Rezoning Transportation Analysis

Petition Number: 2024-031

From: Jake Carpenter, PE

Date	Description
3-27-24	First Review (IW)
04-24-24	Second Review (KC)
05-29-24	Third Review ZC (KC)

SHEET TITLE
SCHEMATIC SITE PLAN

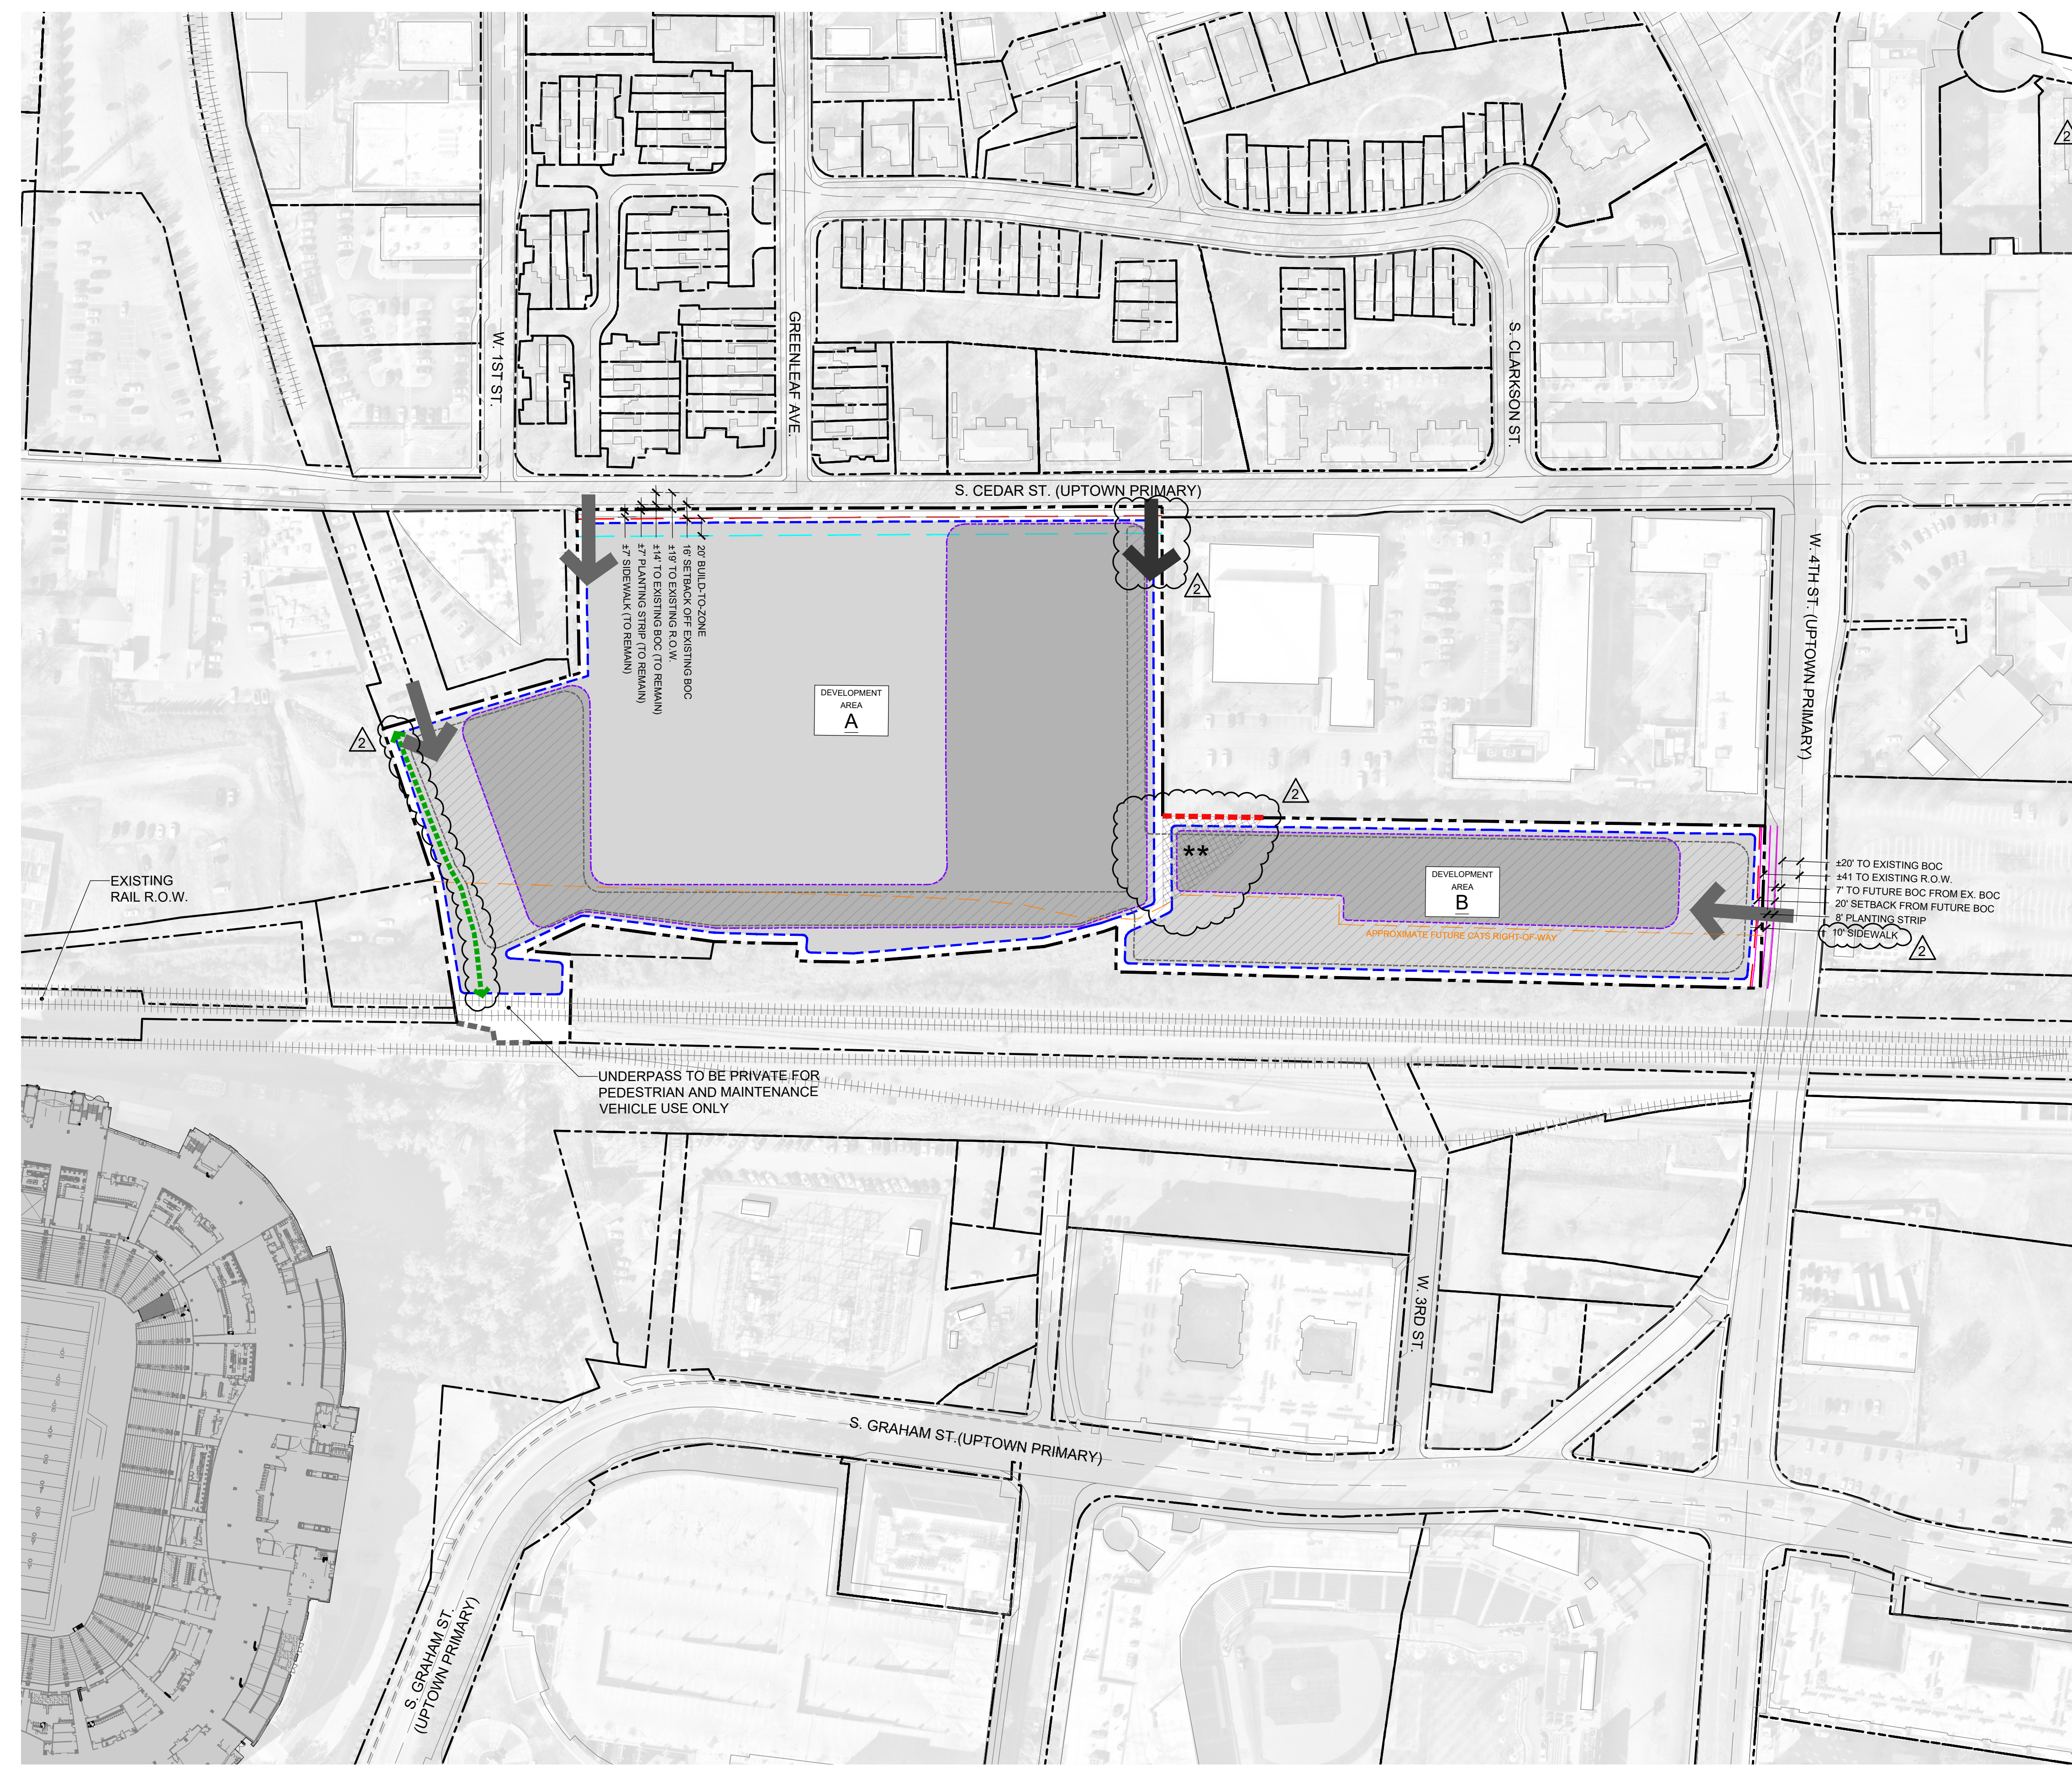
1. ~~Curbline:~~

a. ~~S Cedar Street:~~ The future location of curb and gutter is in its existing location.

b. ~~4th West Street:~~ The location of the future back of curb and gutter is to be 7 feet from the existing curb line per Charlotte Streets Map.

~~Label and dimension the curb and gutter from the centerline for each road on the site plan.~~

- ~~4. Revise site plan and conditional note(s) to commit to creating an 8’ amenity zone and a 10’ sidewalk along w. 4th street, to meet Article 33 in the UDO.~~
